Appeal Decision

Appeal Ref: APP/R5510/D/22/3310851

31 Burwood Avenue, Hillingdon, Eastcote HA5 2RY

- The appeal is made under section 78 of the Town and Country Planning Act 1990 against a refusal to grant planning permission.
 - The appeal is made by Mr P Hare against the decision of London Borough of Hillingdon.
 - The application Ref 22333/APP/2022/1413, dated 29 April 2022, was refused by notice dated 5 October 2022.
 - The development proposed is Proposed first floor side/rear extension and associated works.
-

Drawing Title: PROPOSED BLOCK PLAN & FRONT ELEVATION
Property Address: 31 BURWOOD AVENUE, EASTCOTE, HA5 2RY.
Date: APRIL 2022
Scale @ A3: 1:100 & 1:200 @ A3
Drawing Number: IGD 2210 / HHP 02

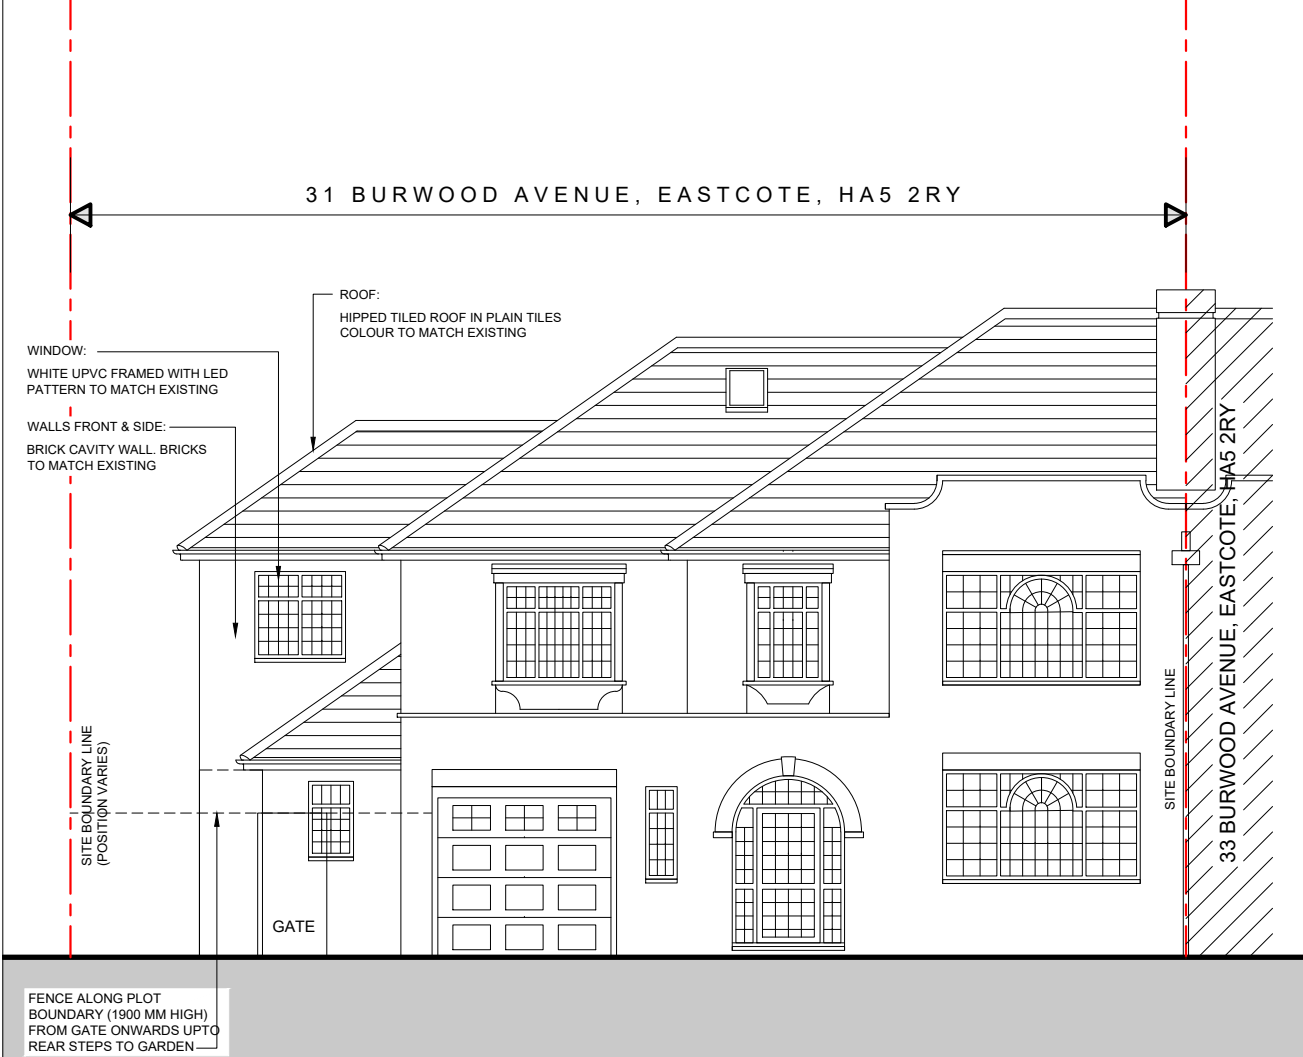
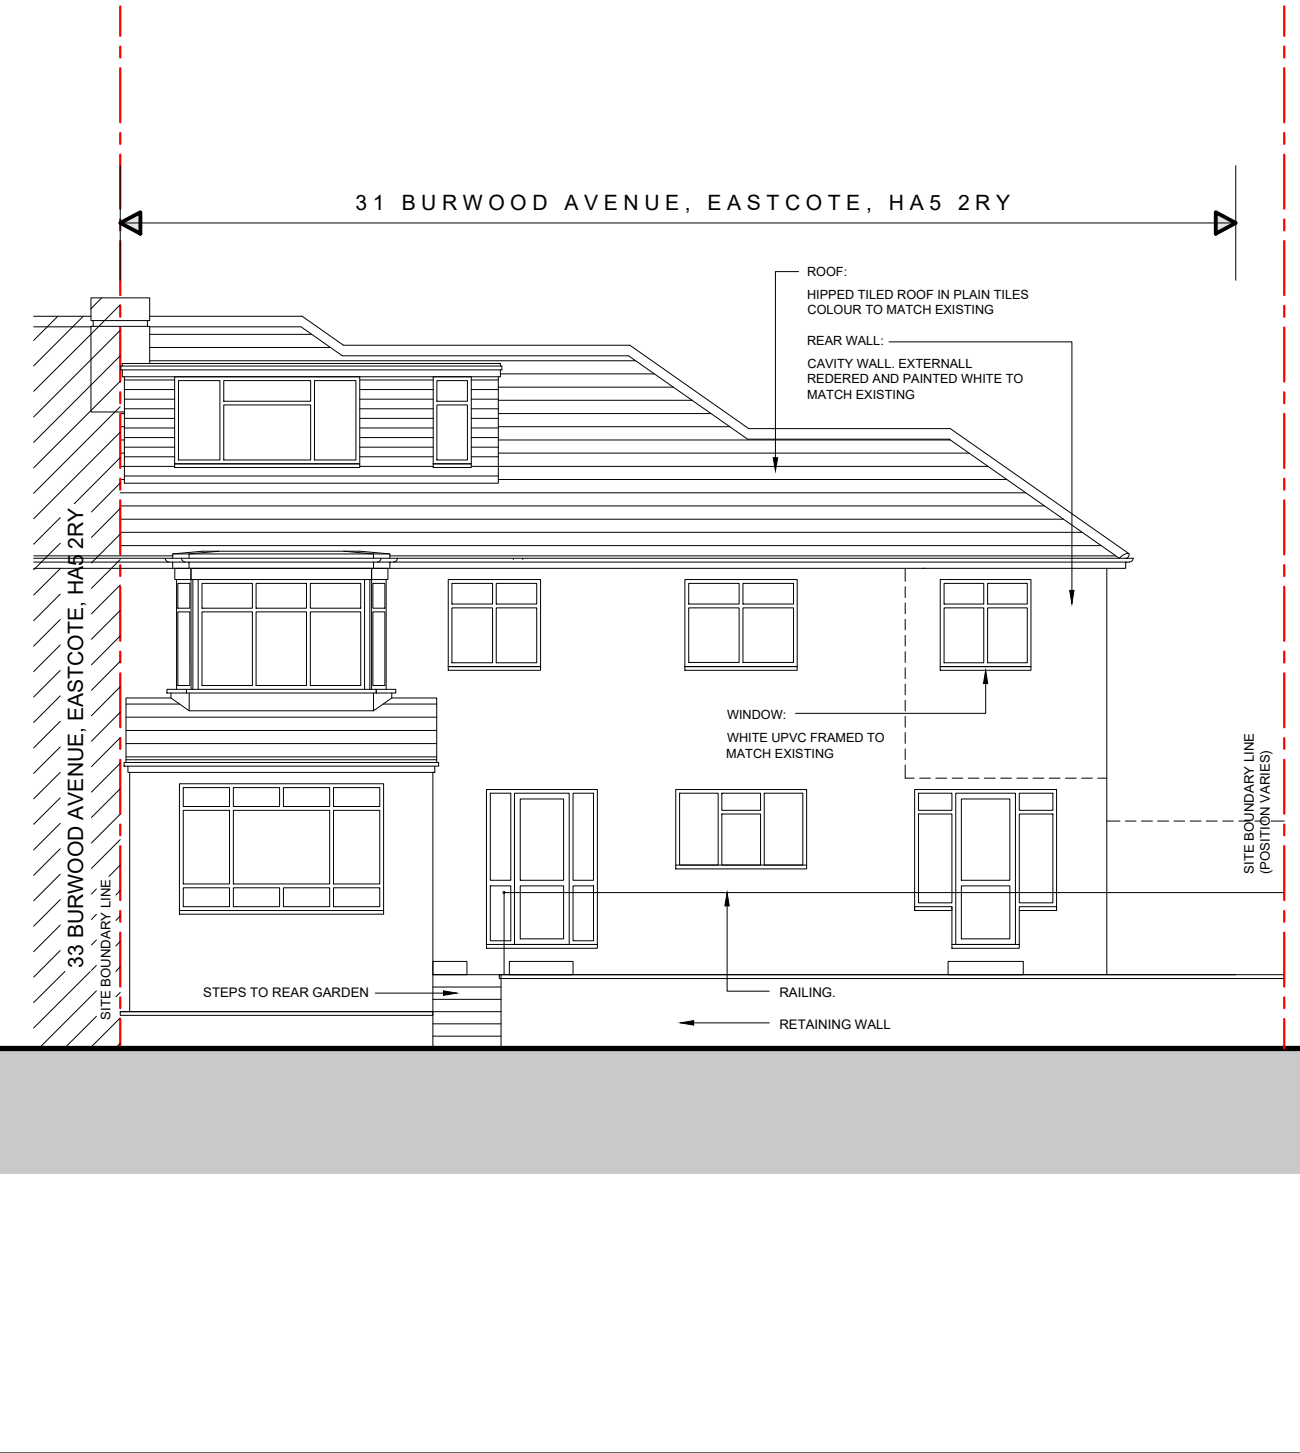
4. The appeal dwelling is situated adjacent to Number 29 Burwood Avenue and semi-detached to Number 33 Burwood Avenue. It has been extended from its original design although retains significant character. The proposal would extend above a single storey element to the side of the dwelling and tie into the existing roof form. Even though it would be set back from the front elevation, it would add substantial bulk and mass to the dwelling by virtue of its overall scale and this would be visible from several vantages within the street scene.

5. The existing roof is stepped and a further step in the roof would only seek to amplify its scale. Overall, I would not view it as a subservient extension to the host dwelling. As the appeal property is a pair of semi-detached houses that retains much symmetry even despite more recent additions, a substantial imbalance would arise thus detracting from the characterful relationship the pair of houses share with one another. The use of matching materials would not lead me to reach a different conclusion.

6. In addition, I am mindful of the contribution the spacing between houses make towards the character and appearance of the CA. The splayed nature of the layout of this house with Number 29, and the fact that the side of the appeal dwelling is single storey, exposes views through of a verdant character.

7. This proposal would considerably diminish this visual gap, made more severe as this gap is limited due to the adjacent layout of No 29. The view from the street scene would lose the verdant characteristics which these gaps are identified within the CA character appraisal to be of intrinsic value to the character and appearance of it. What gap that would remain would be a discernible difference resulting in a negative effect that would not preserve or enhance the character or appearance of the CA.
